RE: **Victory Baptist Church**  
**914 Lasater Road**  
**Bunnlevel, NC**

Re: Application Number – 17-50042037

Thank you for submitting plans for the new Church. The plans have been reviewed by a qualified code enforcement official for compliance with the North Carolina Fire Prevention code and all other fire protection regulations. The following are items that will need to be addressed before a final inspection of this project can be completed. The items are listed and described below.

VICTORY BAPTIST CHURCH

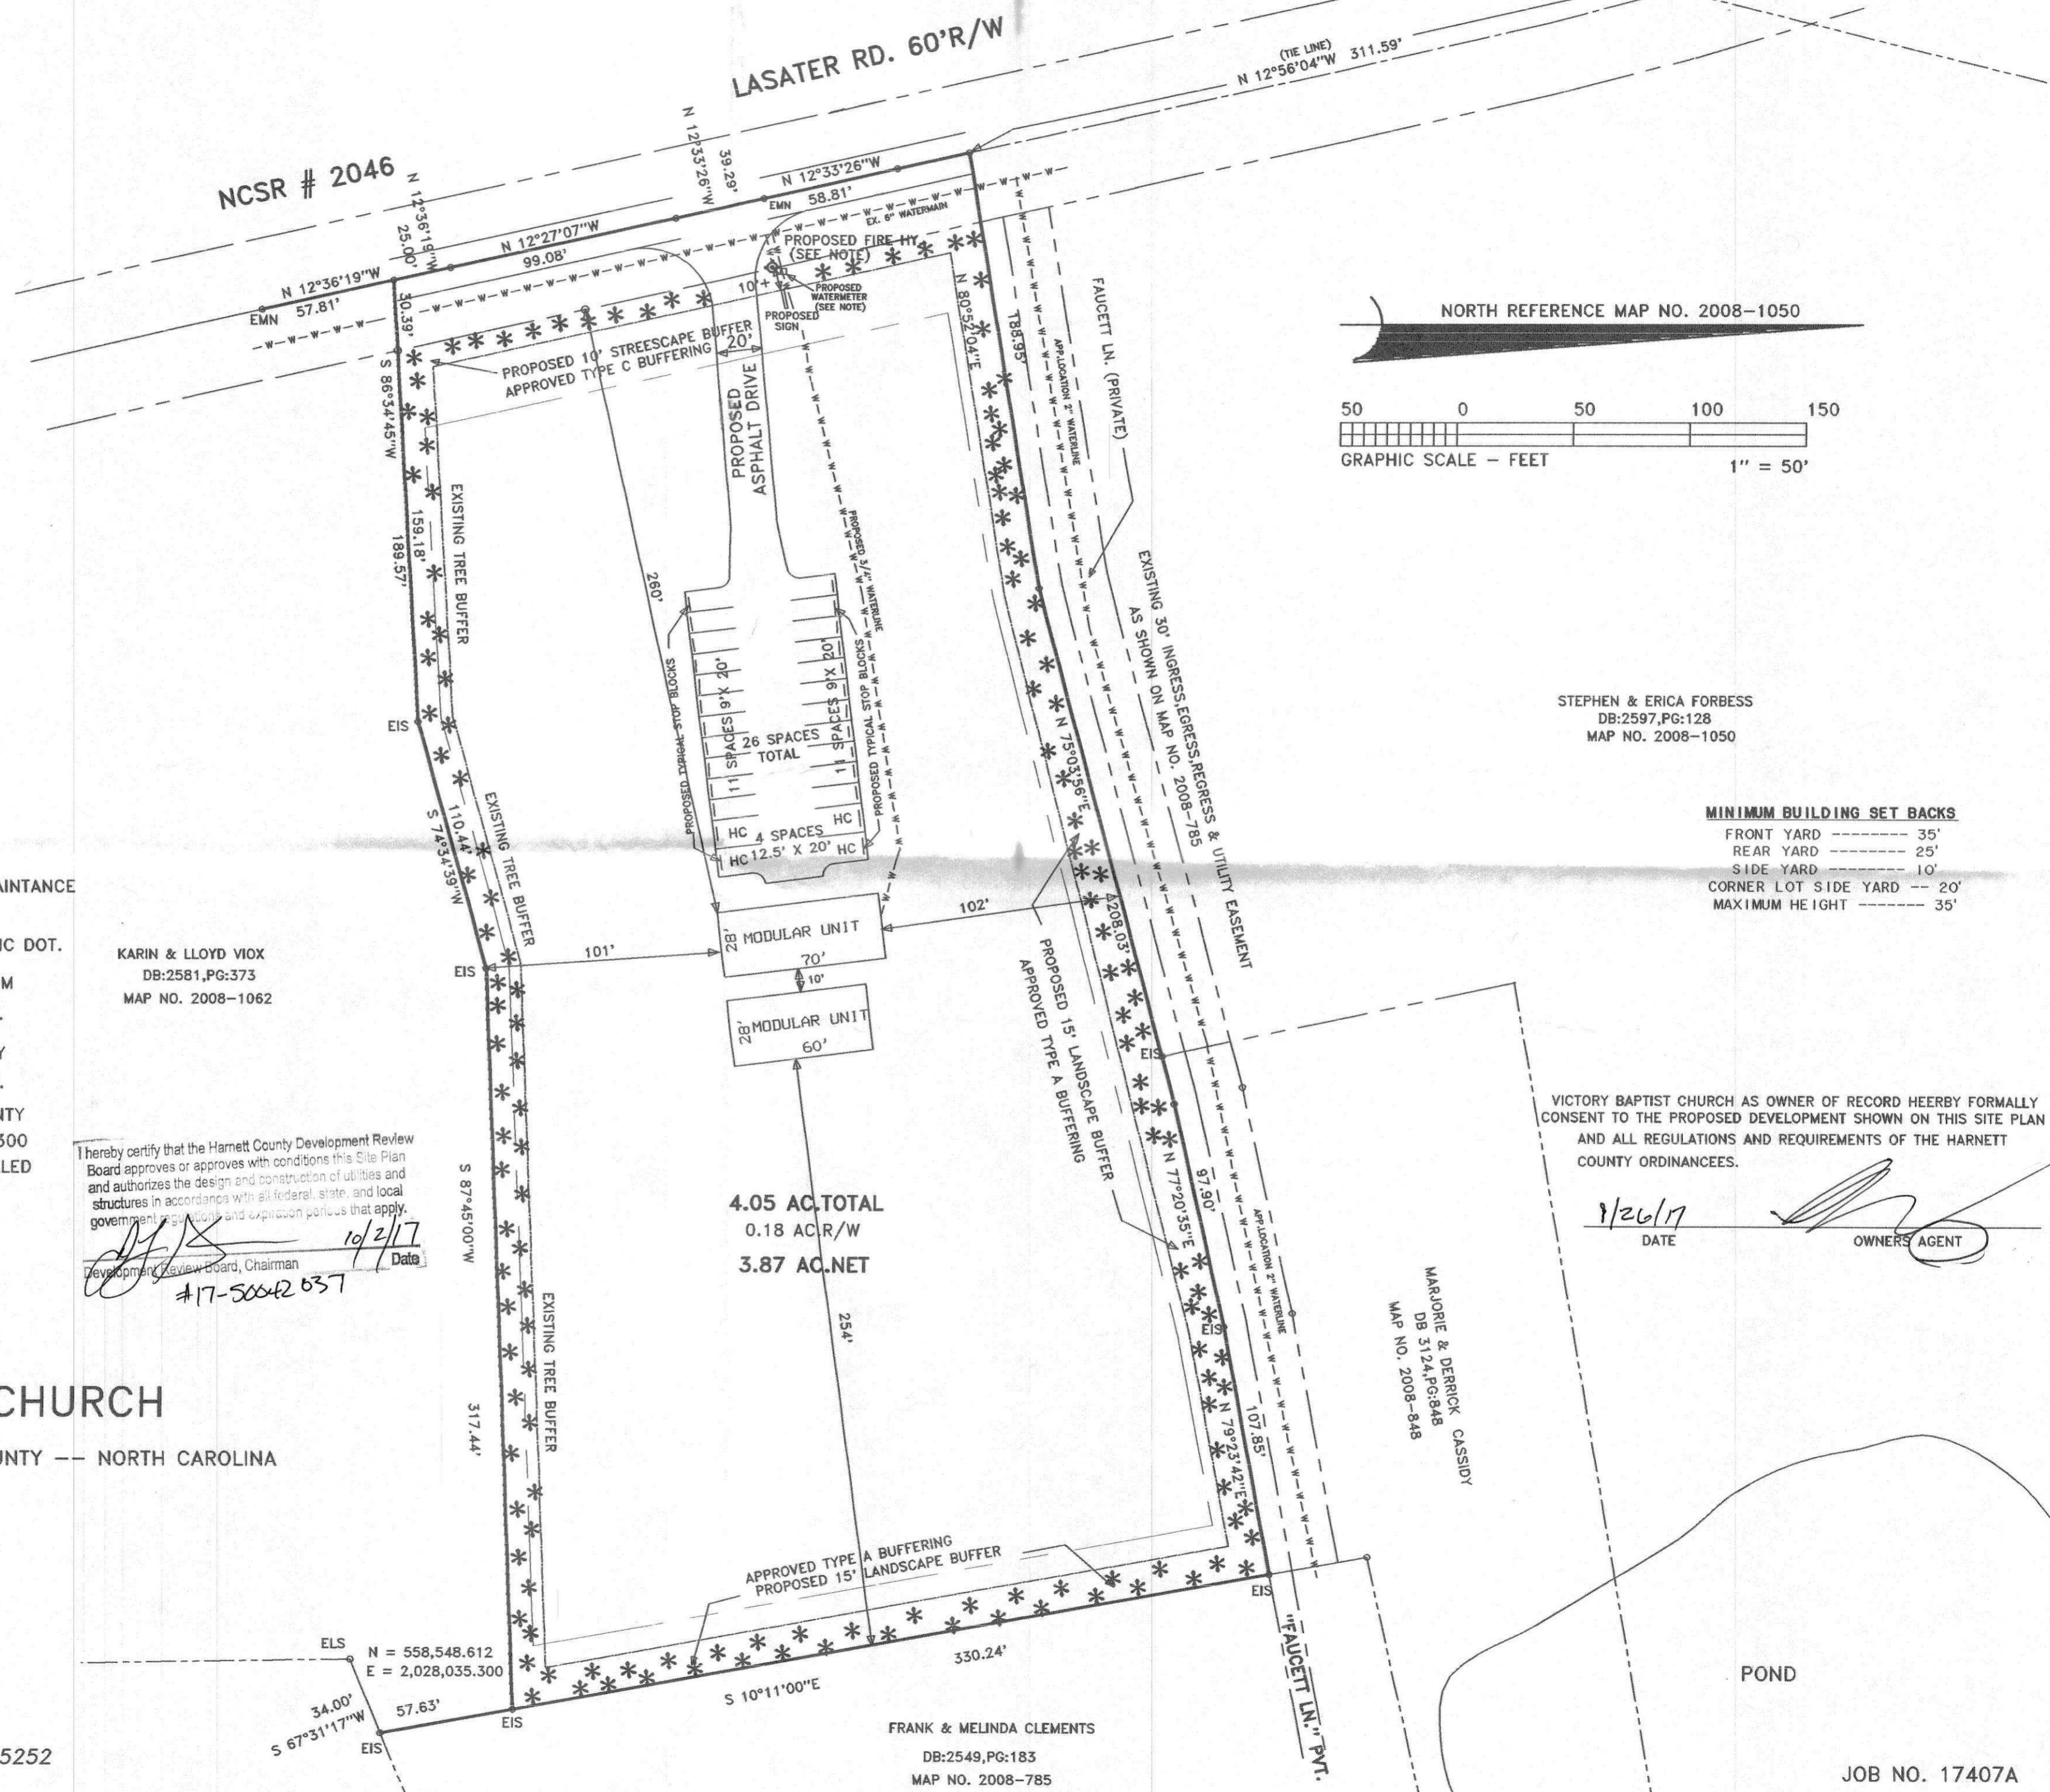
- **503 Fire Department Access**
  - The fire department access shall extend to within 150 feet of all portions of the facility.
  - The fire department access road shall be of an unobstructed width of not less than 20 feet and shall have an unobstructed vertical clearance of not less than 13 feet 6 inches.
